A38 Derby Junctions
TR010022
8.15(a) (Draft) Statement of Common
Ground with
McDonald's

Statement of Common Ground
McDonald's

Version	Date	Status of Version
Draft	2 April 2020	Deadline 10 Submission

Drawing Title  
FIGURE 2.6  
MARKEATON JUNCTION  
GENERAL ARRANGEMENT

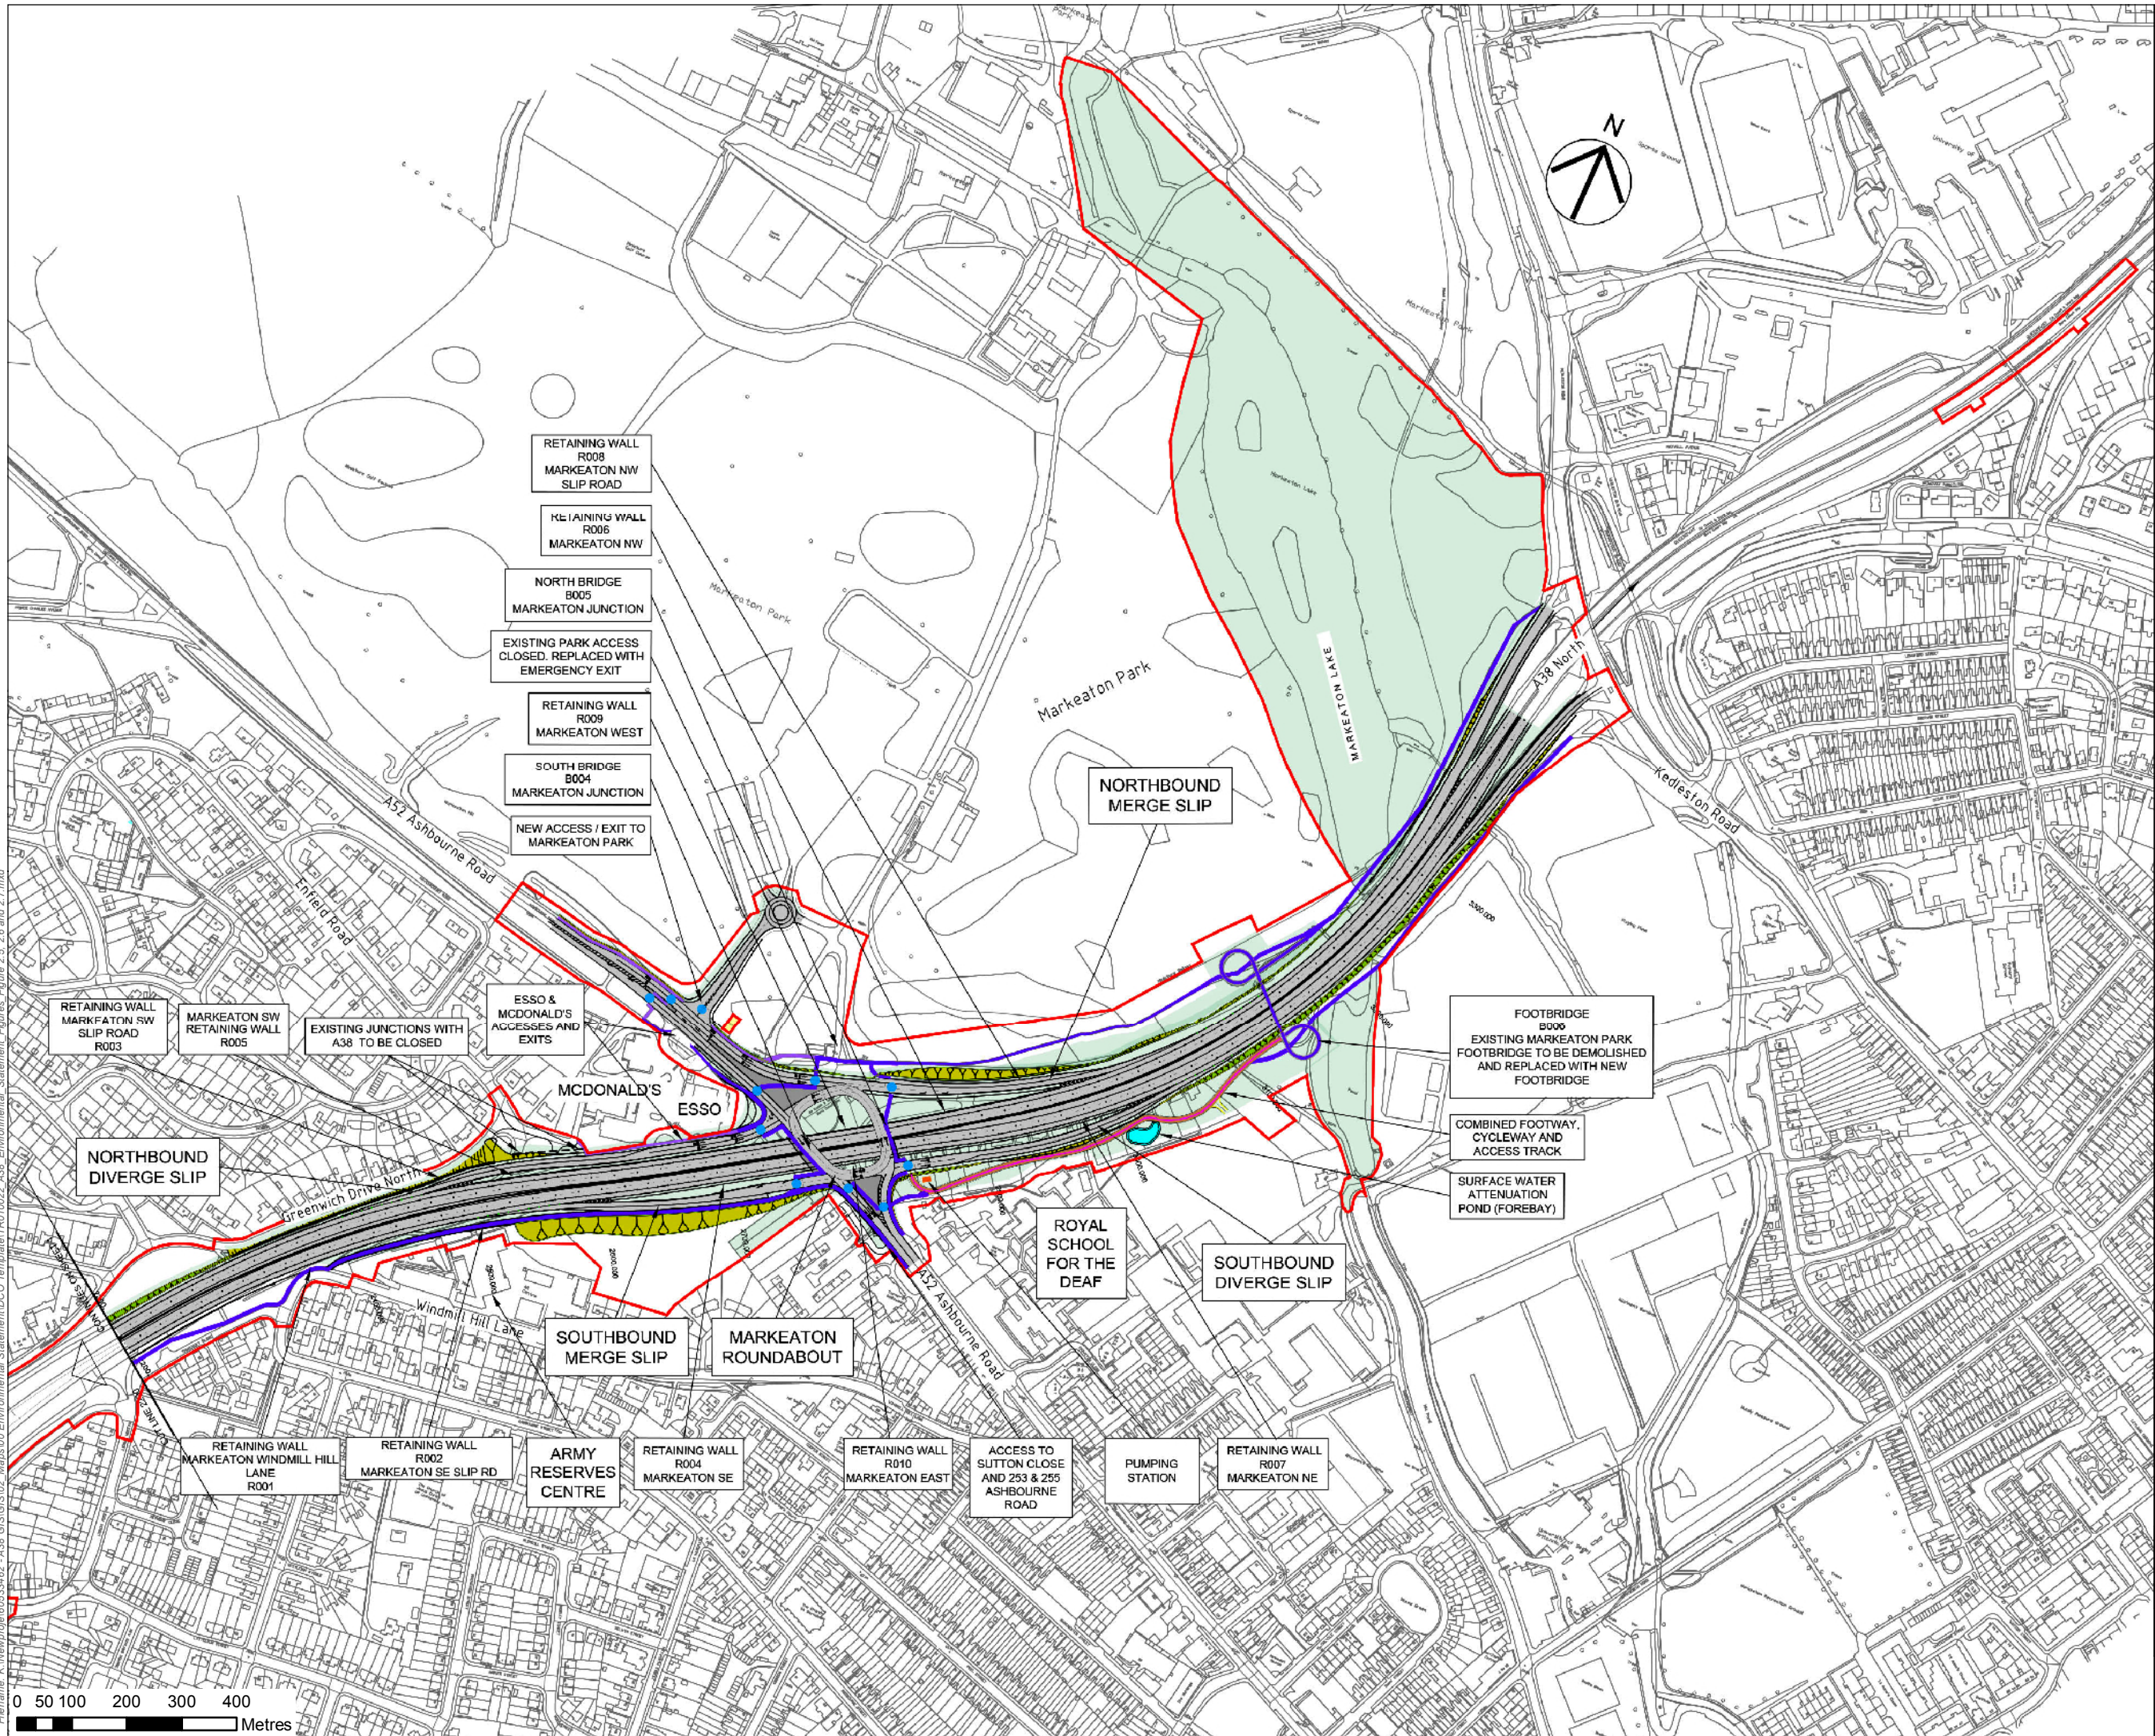
Issues Reference (see Appendix A)	Document	Paragraph Ref	Sub-section	Comment	Highways England Response	Status
Issues ref: I.1, access and economic impact	Written Representation Comments*	Point 1	a)	The Works involve closing the entrance to the Property from the A38. This would cause increased queuing at the Ashbourne Road entrance and exit to the Property, posing a health and safety risk to road users, as well as negatively impacting McDonald's business, brand, sales, operations and the amenity of the local area for residents (in each case during and after the works). Additionally, the increased capacity at the Ashbourne Road junction will go beyond its capability.	Exiting the site onto the A38 will continue to be an option after implementation of the scheme. Entry to the site from the A52 will be via a new signal-controlled junction so will not cause queuing within the site.	Not agreed
Issue ref: I.1, access and safety	Written Representation Comments*	Point 1	b)	The proposed installation of traffic lights at the Ashbourne Road junction will cause gridlock and queuing inside the McDonald's site, especially around the access and egress to the Drive-Thru lanes.	The proposed exit on the A52 should be able to perform better than the existing exit due to the introduction of traffic signals At meeting on the 15 th of Jan 2020, McDonald's agreed to assess capacity by carrying out	Agreed

Issues Reference (see Appendix A)	Document	Paragraph Ref	Sub-section	Comment	Highways England Response	Status
				<p>will exacerbate already existing congestion.</p> <p>No LINSIG results have been provided for review. There is very limited stacking space behind the stop line for a period of high demand. The alignment of the queuing space behind the stop line is inappropriately designed in terms of the alignment with the McDonald's car park exit and the left turn in is very tight for large vehicles</p>	<p>TRANSYT has been chosen (as opposed to LINSIG) to analyse the signalised junction. TRANSYT modelling software is appropriate for both large- and small-scale traffic-signal controlled junctions. The local junction operational model was based on the traffic flows extracted from the larger-scale SATURN traffic forecasting model. The local junction model can be tailored to any size of junction and demand flows may be modified to the criteria required. A LINSIG analysis was undertaken by McDonald's and, as noted above, McDonald's confirmed (in the Deadline 6 submission) that the LINSIG analysis was broadly in agreement with the Applicant's TRANSYT analysis</p>

Issues Reference (see Appendix A)	Document	Paragraph Ref	Sub-section	Comment	Highways England Response	Status
Issue ref: I.1, access and potential impacts	Written Representation Comments*	Point 2	a)	Currently, deliveries to the Property are received five times per week from the A38 entrance. The Works necessitate a change in delivery routes into the restaurant. The proposed route does not account for how McDonald's delivery vehicles manoeuvre around the Property or potential health and safety concerns. Delivery cages weigh hundreds of kilograms and McDonald's' car park is reinforced in the south part only. By closing the A38 entrance, delivery vehicles will no longer be able to service the Property; they are too heavy to safely cross the unreinforced north section of the Property.	<p>Swept path diagrams have been provided to demonstrate that access for deliveries from the proposed new A52 access is feasible within the current car park layout (and crossing onto the Euro Garages land as they do at present).</p> <p>Highways England has advised that, during the detailed design stage, pavement surveys could be carried out to determine the strength of all parts of the car park – strengthening could be carried out as accommodation works if required.</p> <p>Highways England would welcome details of the existing car park construction (strengthened area and non-strengthened area) if available to be able to assess the load bearing capability.</p> <p>At the meeting on the 15th of Jan 2020, McDonald's noted that they have committed to taking core samples in</p>	Under discussion

Issues Reference (see Appendix A)	Document	Paragraph Ref	Sub-section	Comment	Highways England Response	Status
					their car park – the resulting information will be shared with Highways England when available	
Issue ref: I.1, access and safety	Written Representation Comments*	Point 2	b)	Servicing via Enfield Road (if this remains open) is not appropriate since it is unsafe for heavy trolleys to pass across a non-flat route. There are also practical concerns relating to the safe operation of large commercial vehicles.	It will not be necessary to consider routing deliveries via Enfield road if the above proposals are accepted.	Agreed
Issue ref: I.1, safety	Written Representation Comments*	Point 2	c)	<p>A new route for waste collection has been proposed (by Highways England – this would route vehicles through the residential street Enfield Road) which is likely to inconvenience local residents and therefore strain their neighbourly relationship with McDonald's.</p> <p>This will introduce a management issue for McDonald's who will have to coordinate delivery and refuse collections, whereas previously these two activities did not affect each other.</p>	<p>If the refuse vehicles are to access the same collection point as they do at present, they would need to come through Enfield Road residential street (as the A38/Enfield Road access is to be closed by the scheme). McDonald's are concerned that this could lead to complaints from the residents.</p> <p>Highways England has suggested that the vehicles could access the site from the A52 and use the delivery vehicle route – the scheme could include appropriate work (regrading or widening paths) to facilitate getting the bins from the storage area to the pick-up location.</p>	Agreed

Issues Reference (see Appendix A)	Document	Paragraph Ref	Sub-section	Comment	Highways England Response	Status
					At the meeting on the 15 th of Jan 2020, McDonald's agreed that refuse vehicles would use A52 access to enter site.	
Issue ref: I.1, access and potential impacts	Written Representation Comments*	Point 2	d)	<p>McDonald's does not have rights to cross over the adjoining Euro Garages site. The Works rely on McDonald's taking deliveries by crossing over land which it neither owns nor has rights over; this is problematic and allows an adjoining landowner to control the viability of the restaurant.</p> <p>Unless the new delivery route crosses the Euro Garages land in the same place and manner as the existing delivery route, in the absence of a formal arrangement with Euro Garages, McDonald's may not have the necessary rights and will be at risk of a third party preventing deliveries to (and refuse collection from) the restaurant, which would leave it unviable.</p>	Highways England has been advised by McDonald's that this arrangement is how the delivery vehicles currently operate. The scheme proposals are utilising the arrangements that currently exist.	Not Agreed

Issue Reference (see Appendix A)	Document	Paragraph Ref	Sub-section	Comment	Highways England Response	Status
Issue ref: I.1, potential impacts	Written Representation Comments*	Point 3	a)	<p>It appears as though the Works at the junction between the Property and Ashbourne Road encroach onto the Property.</p> <p>HE are proposing that queuing traffic up to the stop line is on McDonald's land. It may be possible that detector loops or similar equipment are required on McDonald's land. This is not standard practice and no detail of maintenance, liability or consideration of McDonald's private plant has been provided.</p>	Highways England does not believe that the proposed layout encroaches onto land owned by McDonald's. However, it may be necessary to install some items (such as signal detector loops) within land owned by McDonald's so an agreement relating to future maintenance of such items will need to be reached.	Under discussion

Issue ref: I.1, access and potential impacts	-	-	-	McDonald's has ongoing concerns over the geometric standards applied to the proposed access/egress with the A52.	Highways England's position is that the arrangements are similar to the existing layout and will be usable for all future traffic. The detailed design stage will be used to refine the design in consultation with DCiC, EGL and McDonald's and the final design will be subject to a Stage 2 Road	Under discussion

Issues Reference (see Appendix A)	Document	Paragraph Ref	Sub-section	Comment	Highways England Response	Status
					<p>their own LINSIG analysis of the junction.</p> <p>McDonald's confirmed (in the Deadline 6 submission) that the LINSIG analysis was broadly in agreement with the Applicant's TRANSYT analysis and the junction would be able to accommodate the waiting vehicles. McDonald's did raise some caveats that the Applicant would be willing to discuss and refine the design during the detailed design stage. Also, fine adjustments can be made to the signal timings during commissioning to react to the 'real' situation.</p>	
Issue ref: I.1, assessment of impacts	Written Representation Comments*	Point 1	c)	The site traffic survey undertaken in 2015/16, which formed the assessment of the Works, is outdated and guest numbers to the Property have subsequently risen. The assessment of the impact does not account for this increase; the Works and increased site traffic	A Technical Note covering this and point 1a and 1b above has been prepared by Highways England's designers and this shared with McDonald's. This provides details of the traffic signal phasing and queue lengths for the design traffic flows.	Agreed
